comment response in RED below

INTAKE COMMENTS CST		Reviewer	
		Email	
		Status	
		Intake #

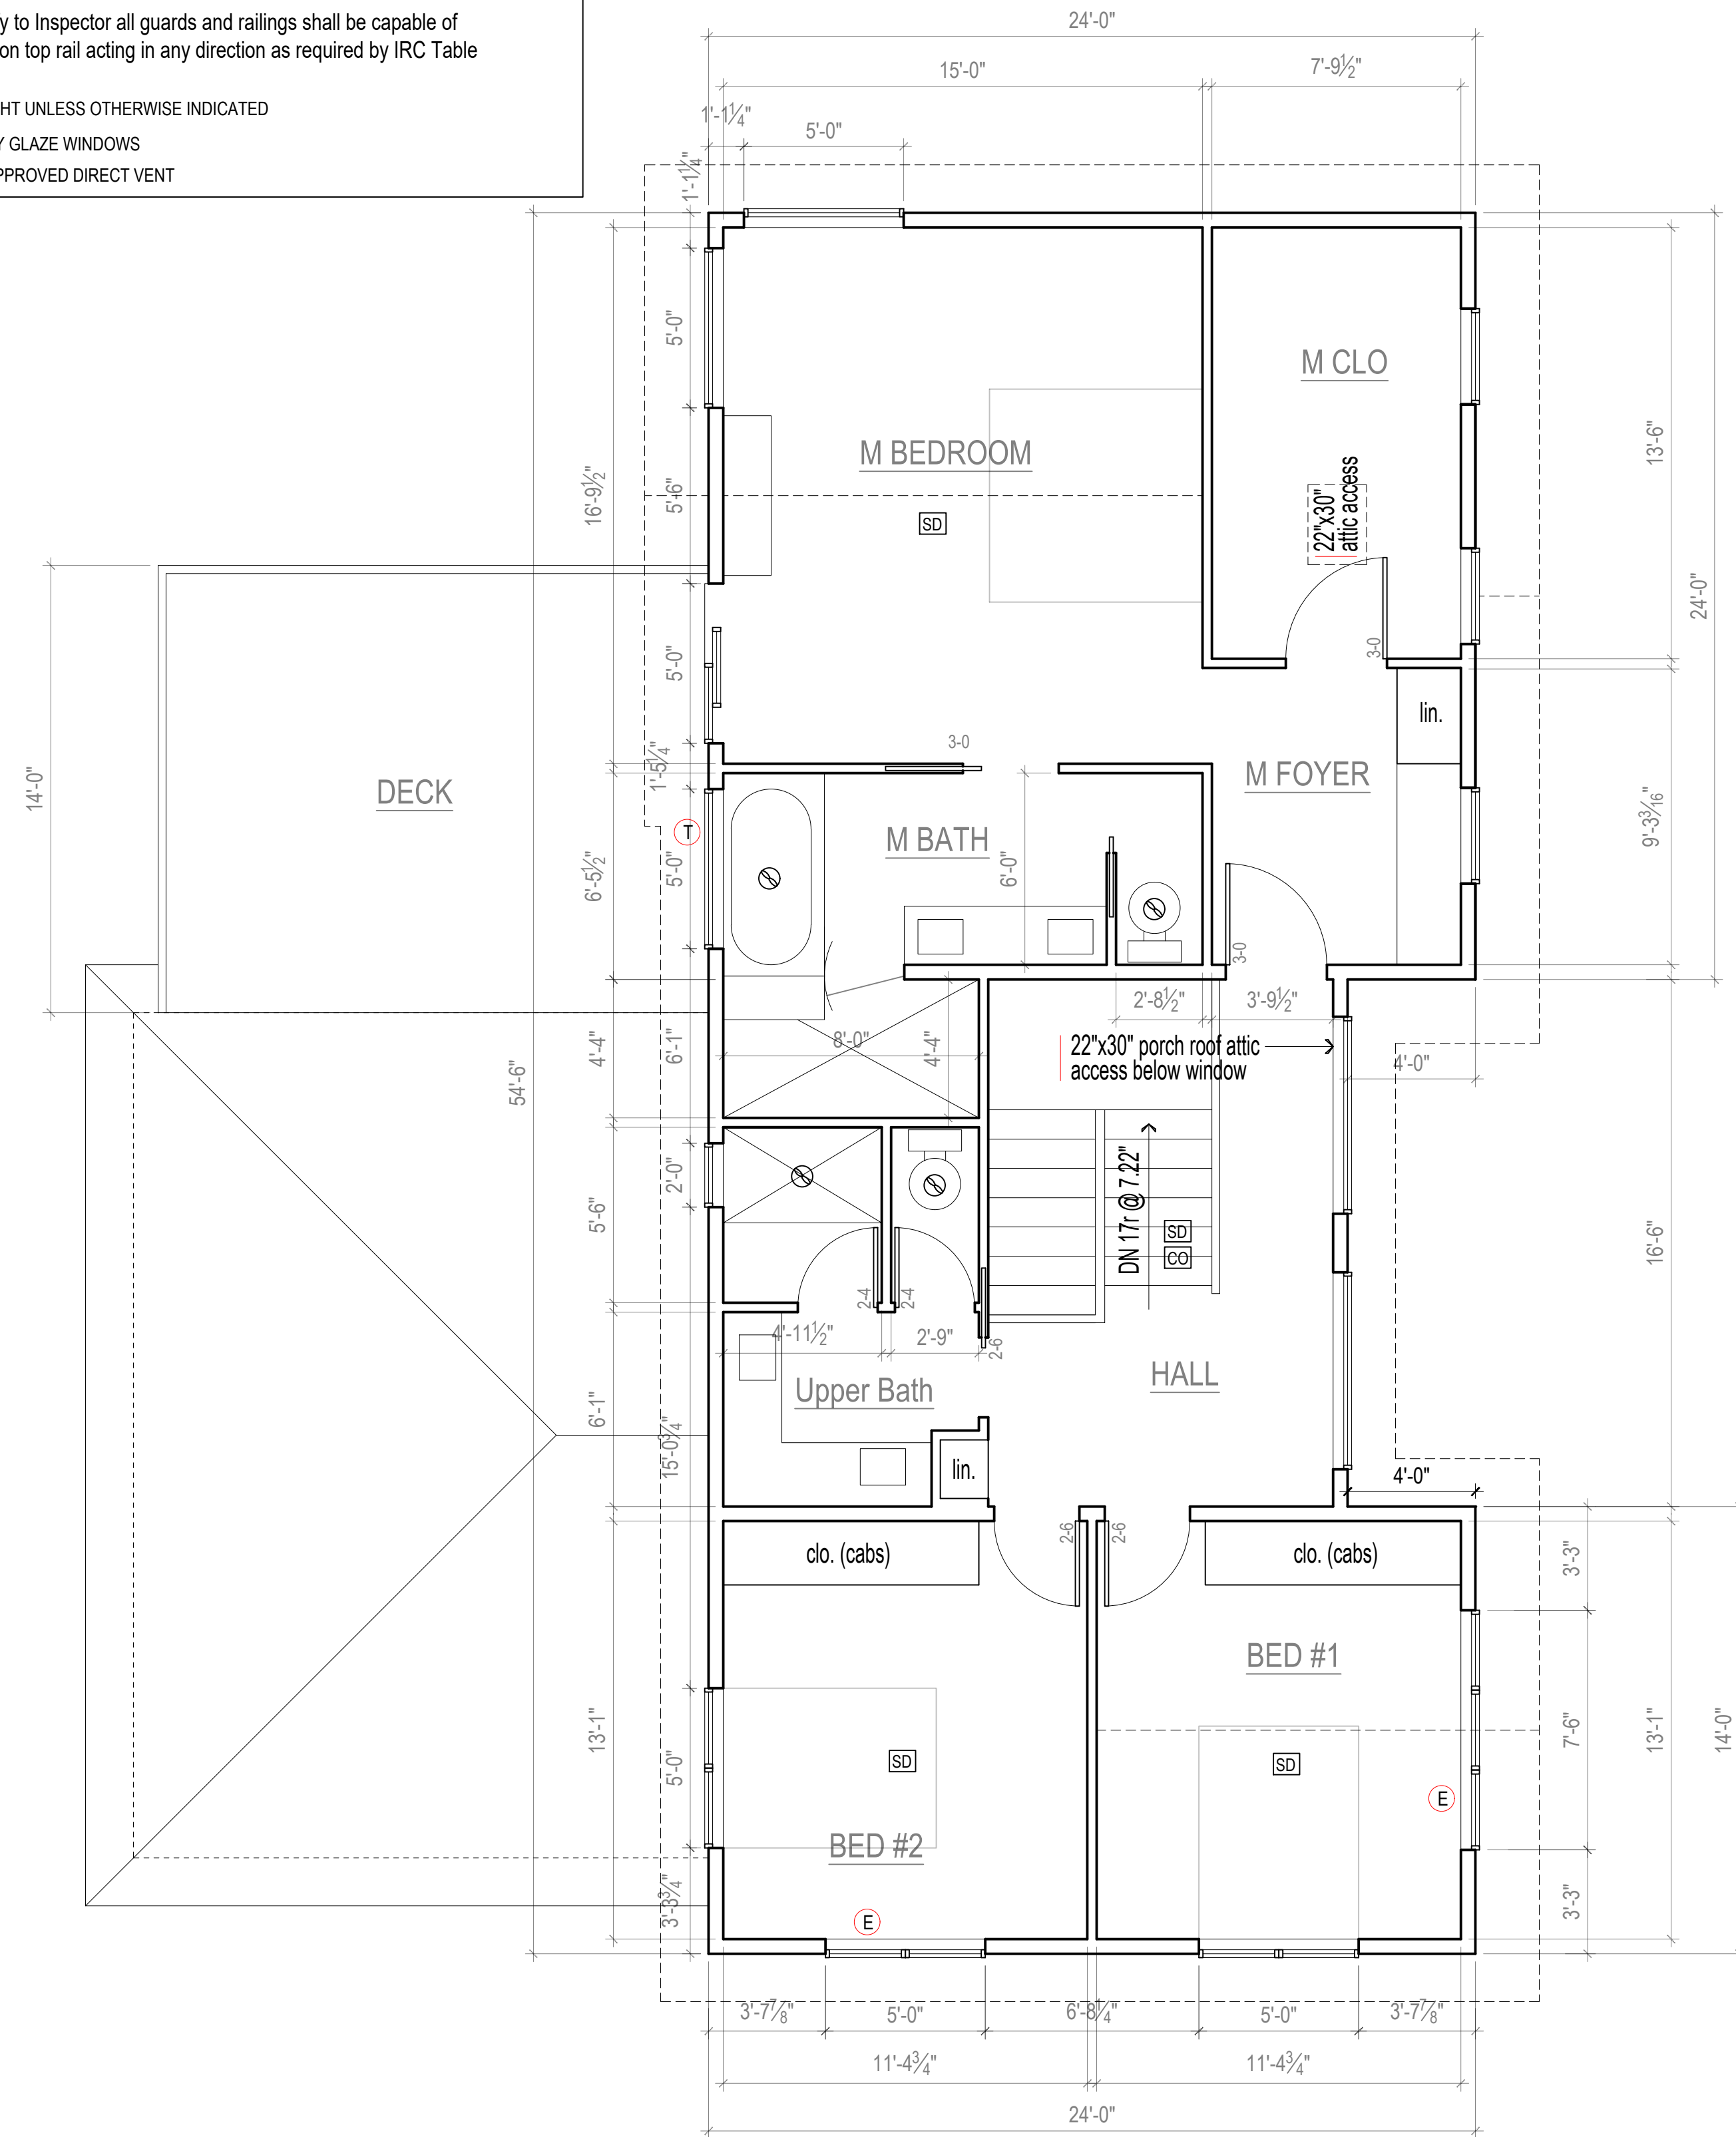
plans updated to include basement calc., and eave into 5' setback removed

(8) TREES REQUIRED
50% PNW TREES

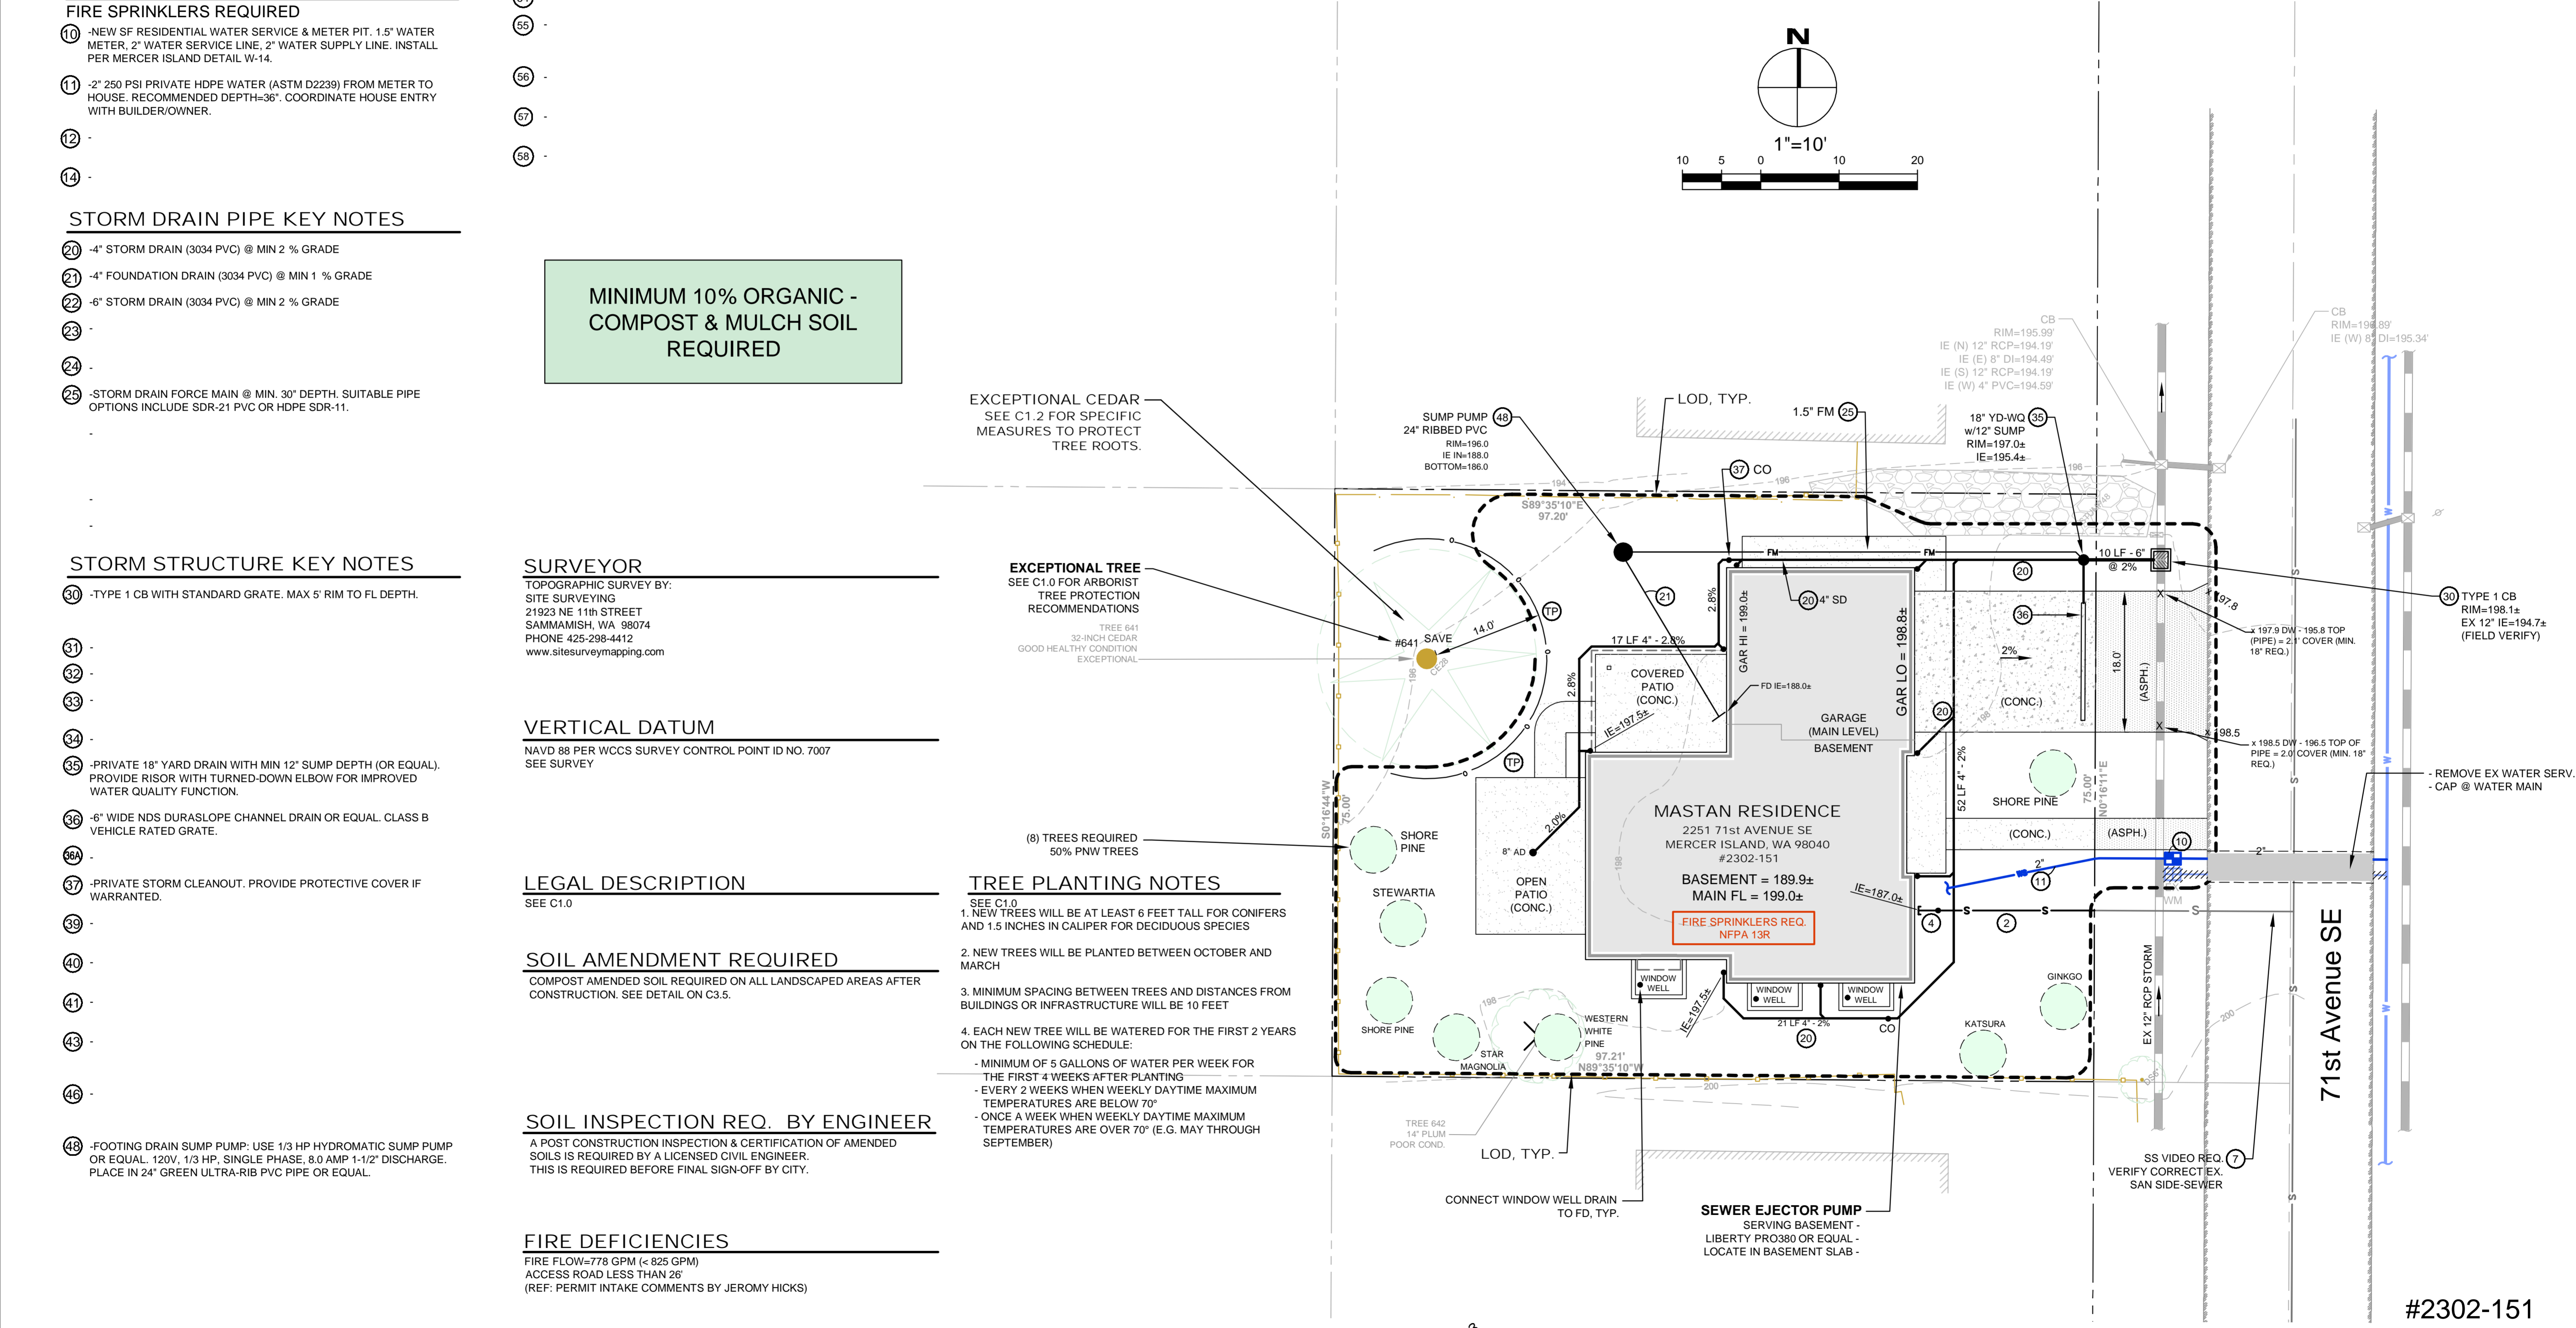
tree inventory worksheet added, and additional replacement trees added to Civil drawings
